711 #1057022 BRADLEY AND LEGACY (EL PASO CO)

ELEVATION VIEW

EAST ELEVATION

EAST ELEVATION

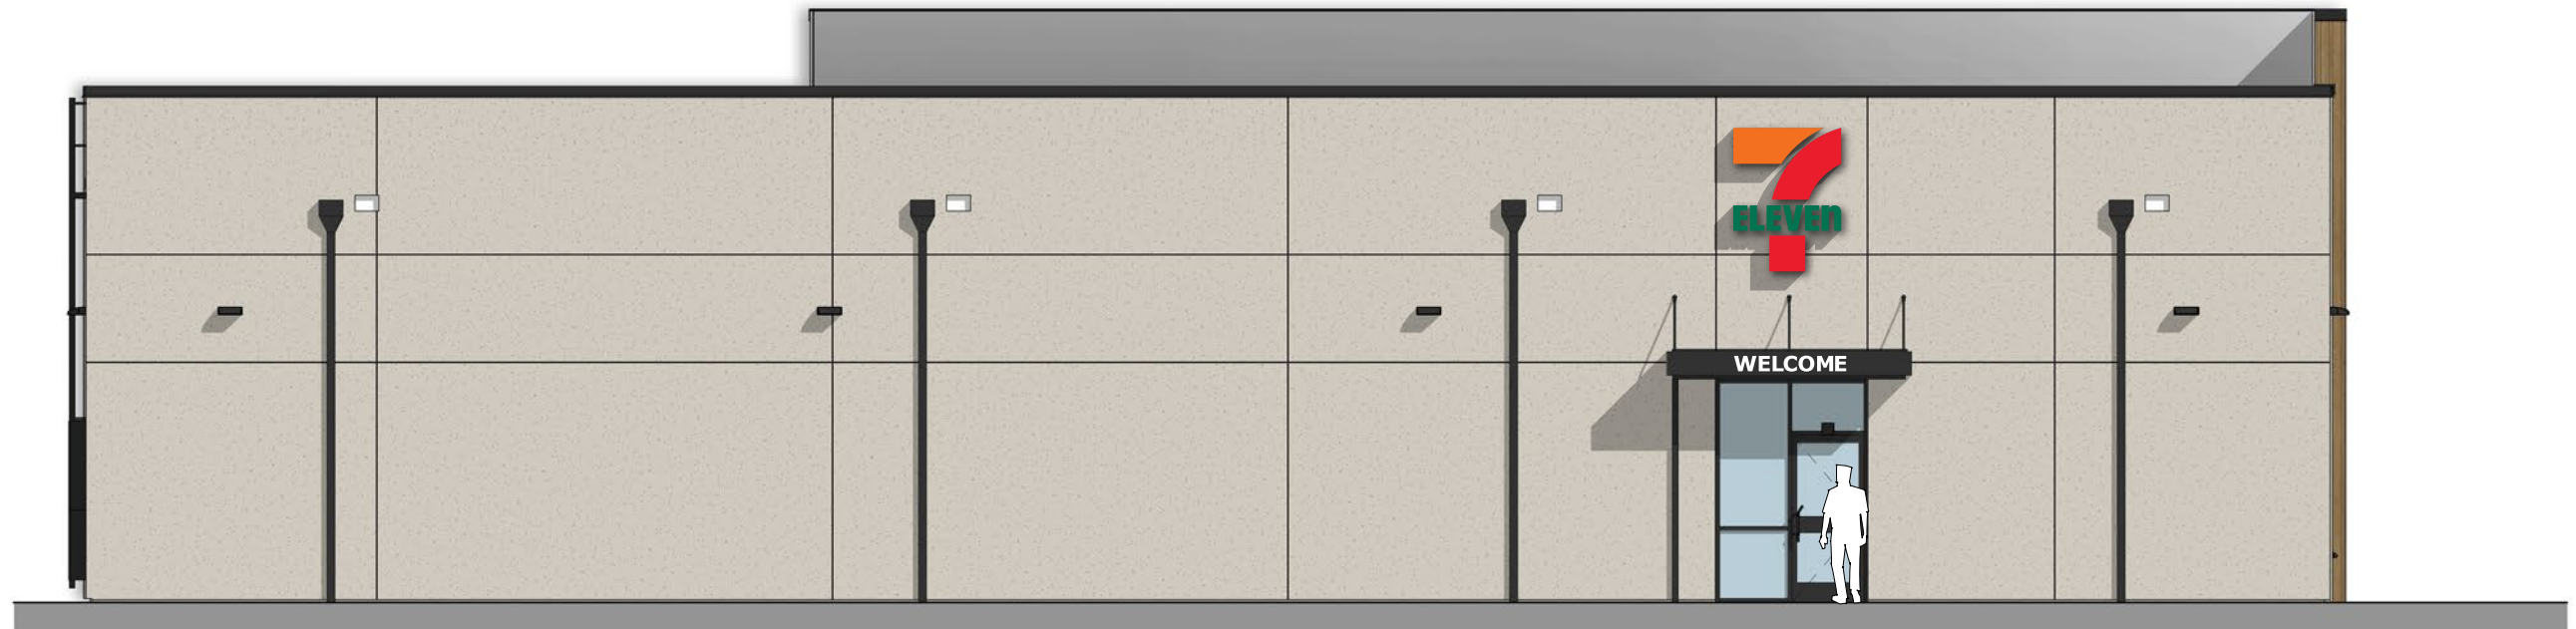
Add note "CSU Field Engineer to determine final gas meter and service line locations. Contact Field Engineering at 719-668-4985 (Gas) with any questions."

Please show gas meter and add note " Gas meters must be a minimum of 3-foot from doors, operable windows, or any vents or openings in walls."
